Re: Site Development Plan PPR2615 — Honor Charter Academy, Bent Grass Meadows Drive, Peyton, CO

Landscape Review — Request for Approval of Alternative Landscaping Plan under El Paso County Land Development Code § 6.2.2(A)(4)

AS101

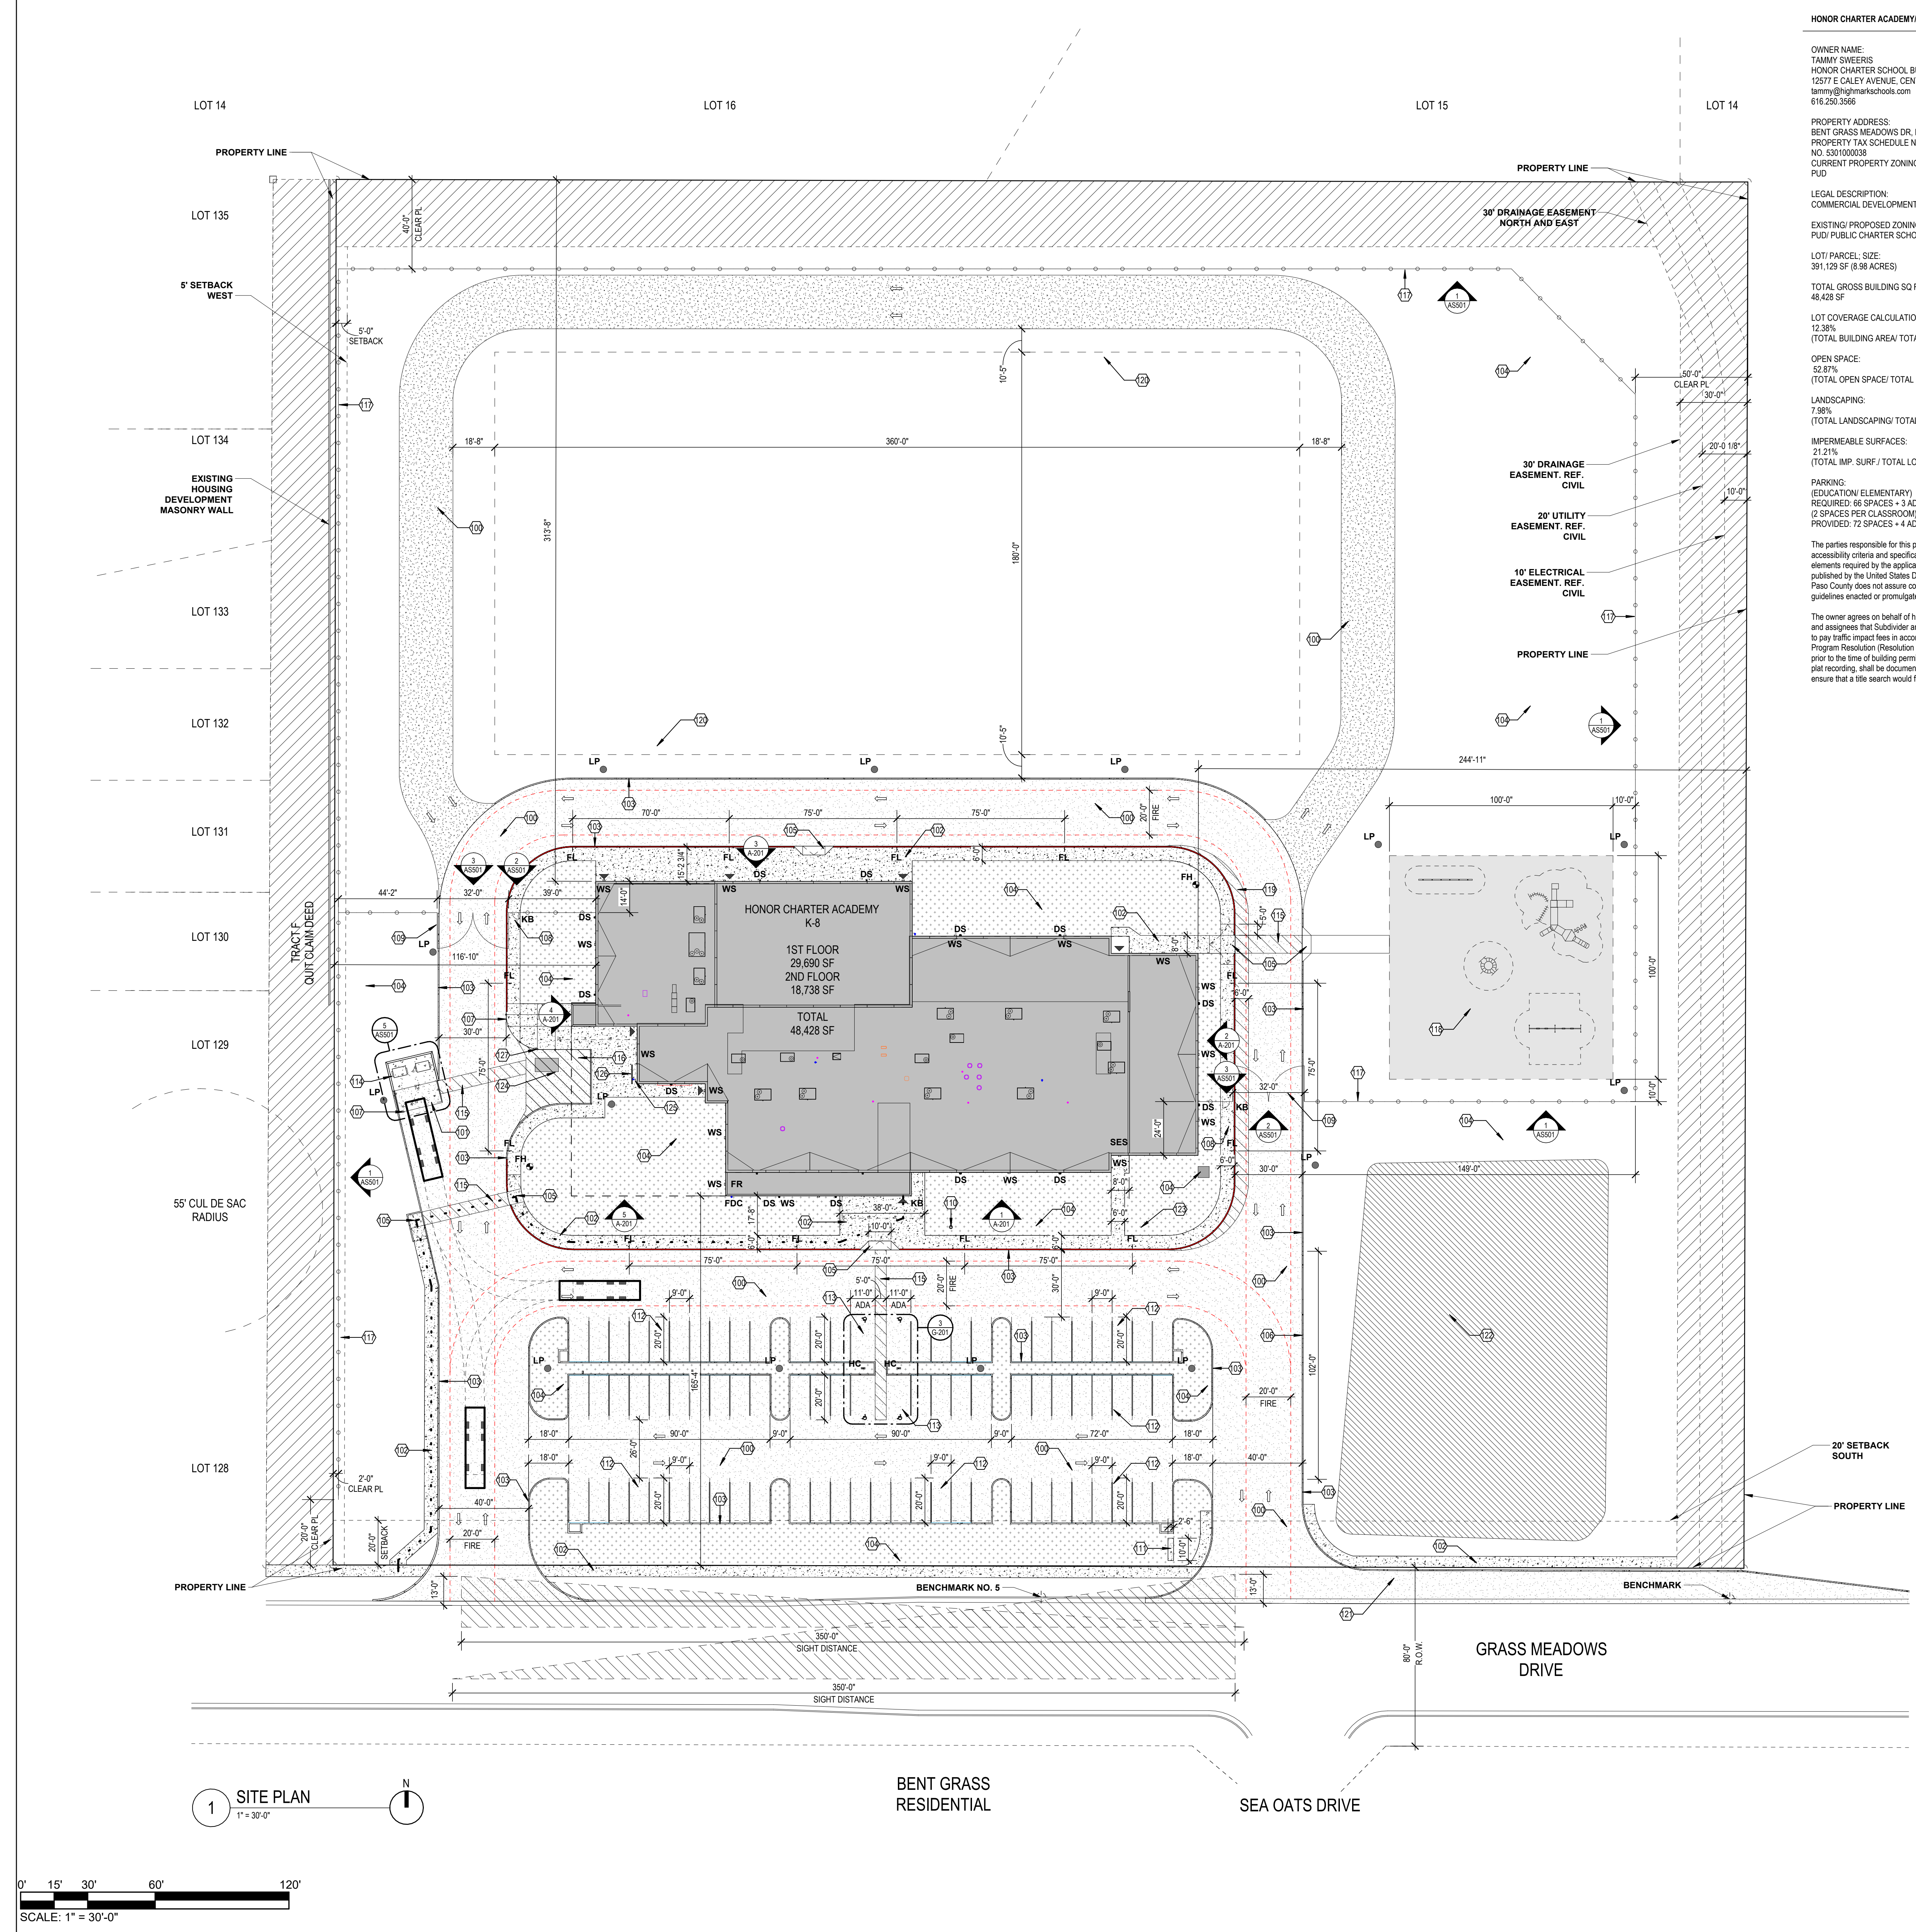
this shall be 100% screened ;enclosed - provide details to screen from adjacent residents; add dimension to property lines; 25' setback from property lines.

Review 1 comment not addressed. 25' setback from property lines need to be showed and dimensioned.

Add screening fence detail

TAIT RESPONSE:
THE SETBACKS HAVE BEEN ADJUSTED TO MATCH THE SITE DEVELOPMENT PLANS. THE SITE DEVELOPMENT PLANS HAVE THE SETBACKS LABELED AS "25' BSL" AND "15' LSL". THE TRASH ENCLOSURE HAS BEEN ROTATED AND SHIFTED TO KEEP OUTSIDE OF THE 25' BSL.

THE SCREEN FENCE DETAIL IS ON THE PROVIDED ARCHITECTURAL PLANS AND THOSE PLANS HAVE BEEN REFERENCED ON SHEET LP-2.

LP-1

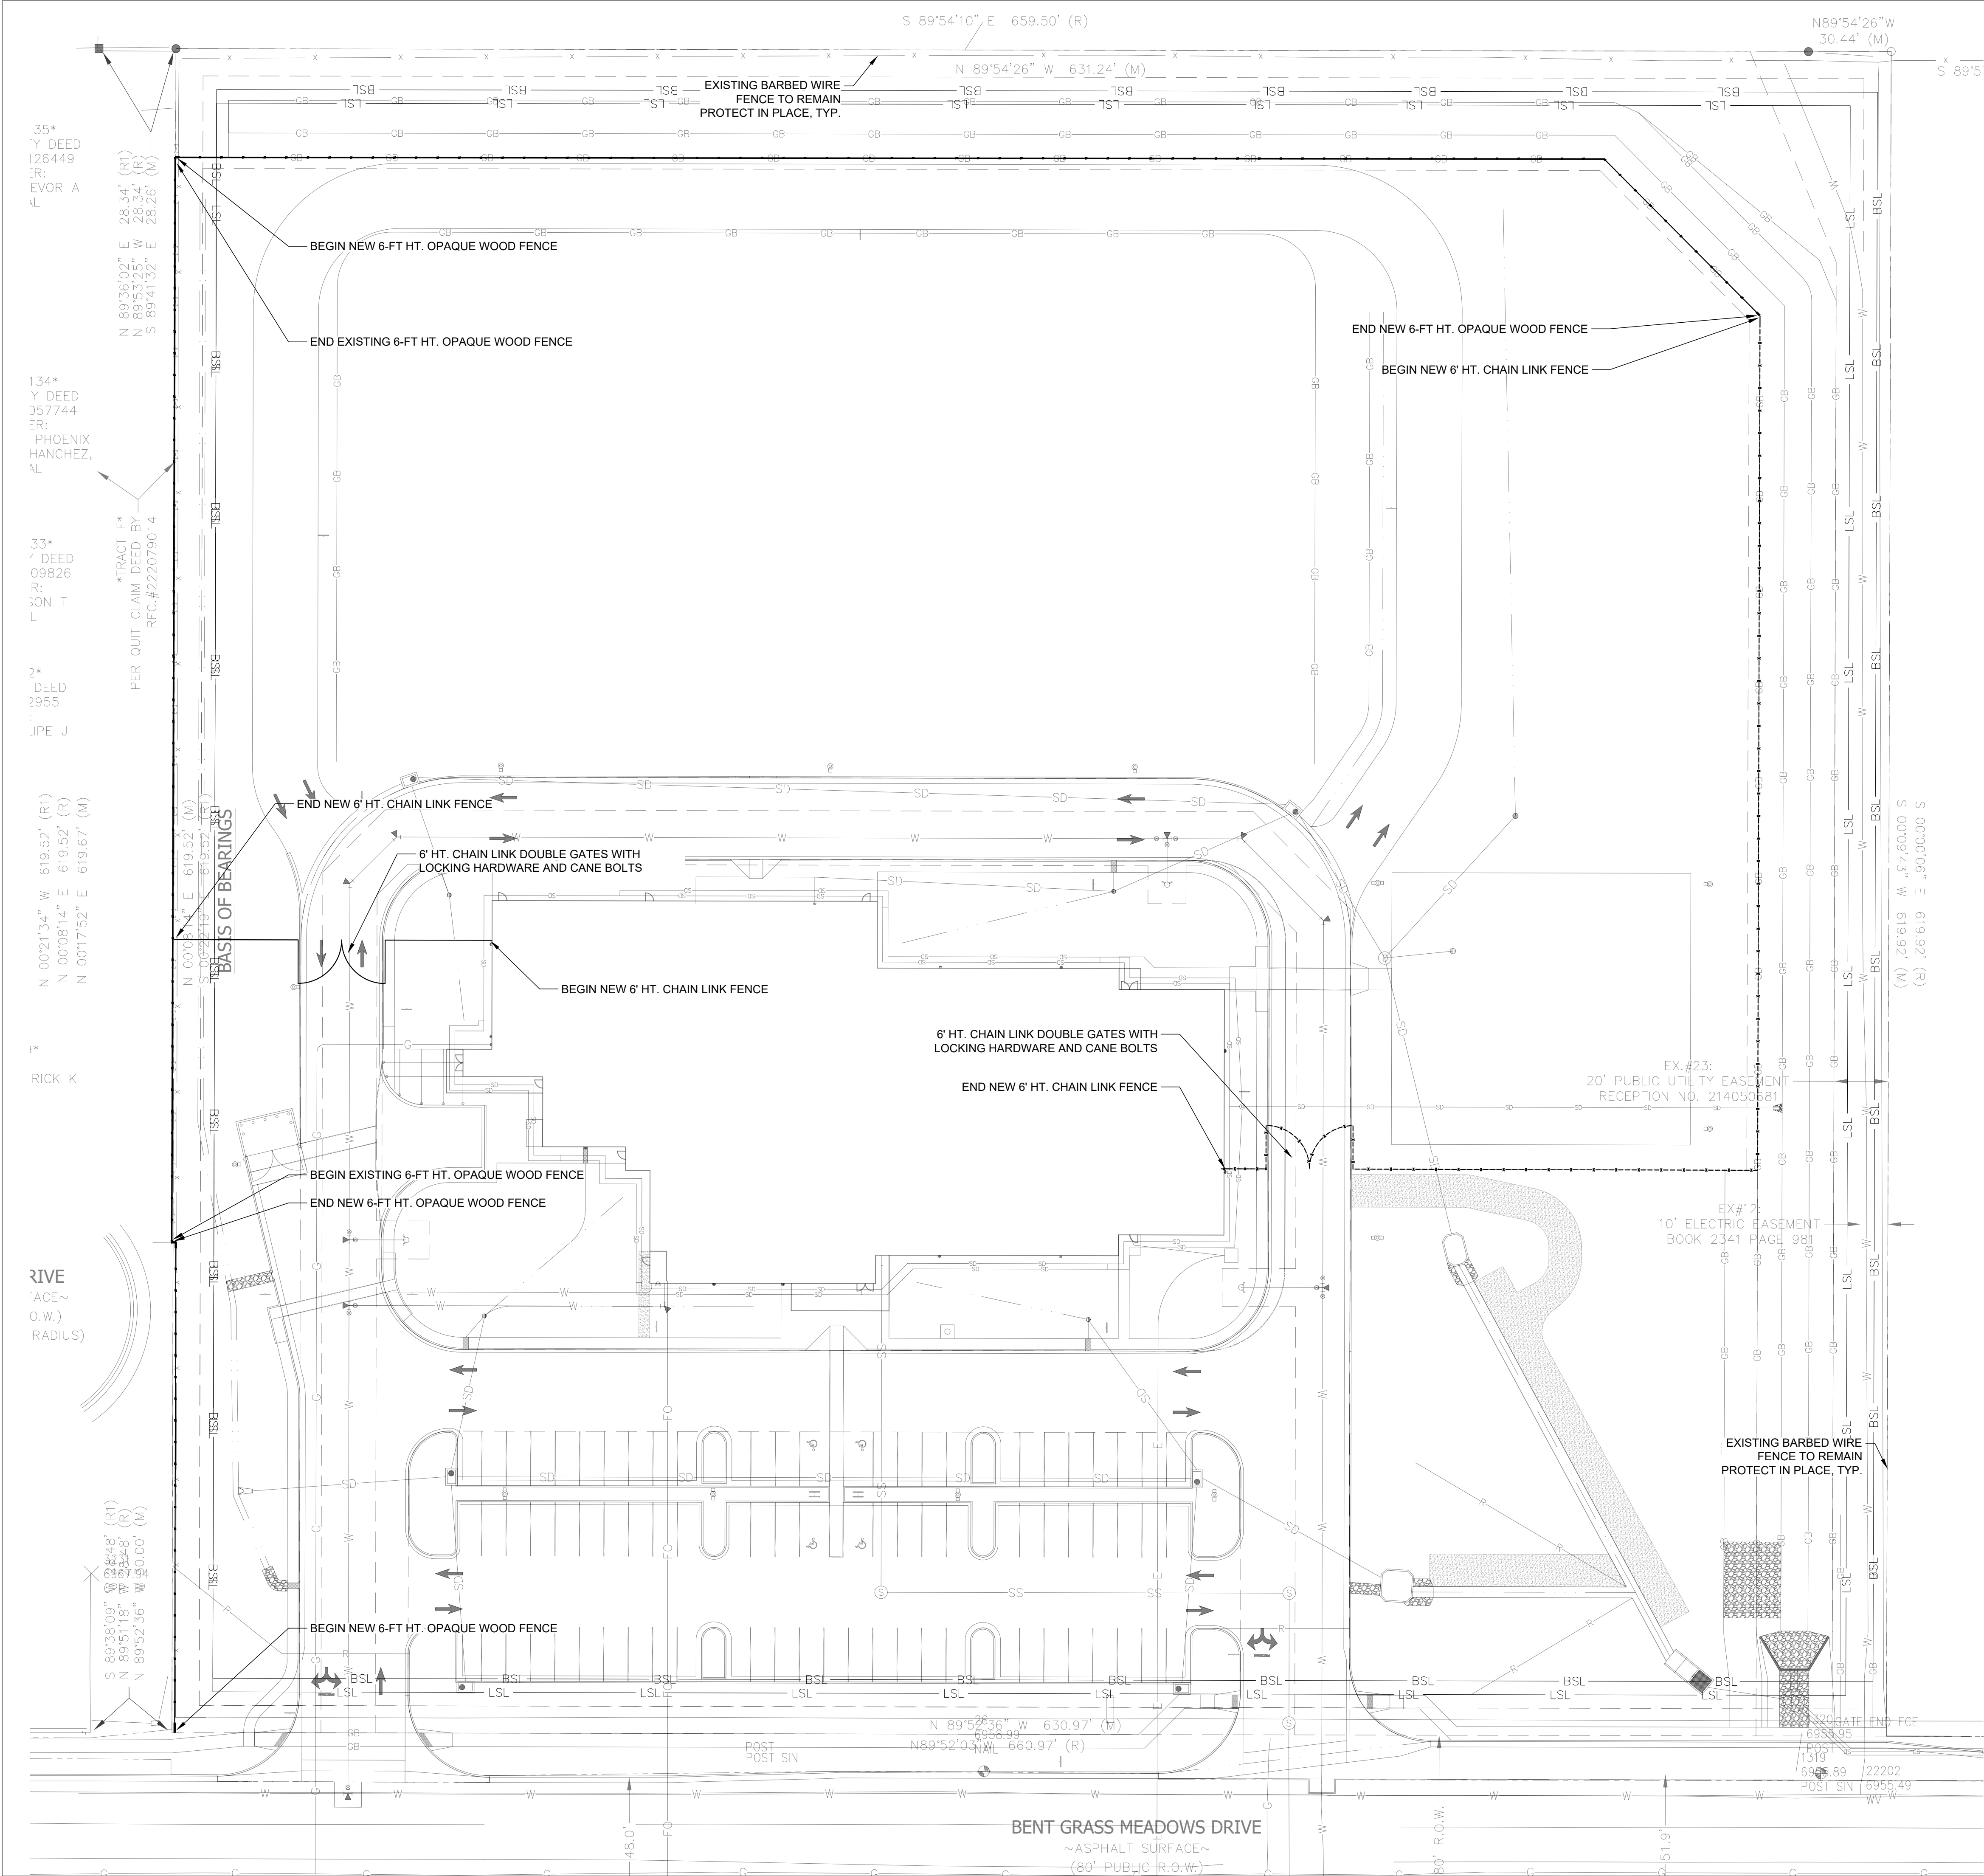
It looks like the landscape plan didn't address comments; it does not meet the standards in the Code for buffers, roadway and internal landscape.

There is mention of tree credits? We don't have tree credits that I am aware of. A school is not exempt from zoning as indicated on the Plan. Are you proposing an alternative/substitute landscape plan? If so, you will need to state the justification in the table on the Plan. I am sending you my comments on the landscape plan via email so you don't have to wait until the remainder comments on other documents are published, so you can make adjustments.

Provide the alternative justification for each area you are omitting landscape from please

add all the screening fences to all property lines all sheets

label the dimensions of the setbacks

make sure fencing is consistent on landscape plan and matched site dev plan set

Thank you for your review comments on the Honor Charter Academy landscape plan. We acknowledge that the project is not exempt from the landscaping standards of Land Development Code § 6.2.2, and we are revising Sheet LP-1 to remove the "Project is Zoning Exempt" note that appeared on the buffer landscape calculations.

In its place, and as you invited in your comment, we respectfully request that the Planning and Community Development Director approve an alternative landscape design for the north, east, and west buffer areas pursuant to LDC § 6.2.2(A)(4). That section authorizes the Director to approve landscaping that does not meet the Section's specific numeric requirements where the proposed design still meets the Section's purpose, promotes the concepts of the Landscaping and Planting Manual, and provides the community and environment a benefit equivalent to strict compliance. We believe the revised plan, together with the justification below, satisfies that standard, and we ask that this letter be treated as the justification to be carried onto the LP-1 landscape calculation table.

TAIT RESPONSE:
PLEASE SEE ATTACHED LETTER FOR THE
REQUEST FOR APPROVAL OF AN
ALTERNATIVE LANDSCAPING PLAN.

TAIT RESPONSE:
PLEASE SEE ATTACHED LETTER FOR THE
REQUEST FOR APPROVAL OF AN
ALTERNATIVE LANDSCAPING PLAN.

TAIT RESPONSE:
SCREEN FENCES WERE INCORRECTLY PORTRAYED ON THE SITE PLANS AND SITE PLANS HAVE BEEN UPDATED TO MATCH THE LANDSCAPE PLANS. FENCE ALONG THE NORTH PROPERTY LINE WILL REMAIN TO BE THE EXISTING BARBWIRE FENCE. A SOLID WOOD SCREEN FENCE IS BEING SHOWN ON THE SOUTH SIDE OF THE DRAINAGE SWALE ALONG THE NORTH SIDE OF THE SITE.

TAIT RESPONSE:
THE SETBACKS HAVE BEEN ADJUSTED TO MATCH THE SITE DEVELOPMENT PLANS. THE SITE DEVELOPMENT PLANS HAVE THE SETBACKS LABELED AS "25' BSL" AND "15' LSL".

THE SITE DEVELOPMENT PLAN HAS BEEN ADJUSTED TO MATCH THE LANDSCAPE PLANS. THIS SCREENSHOT OF THE SITE DEVELOPMENT PLANS SHOWED THE SCREEN FENCE IMPROPERLY. THE SCREEN FENCE IS BEING PROVIDED ON THE SOUTH SIDE OF THE DRAINAGE SWALE.
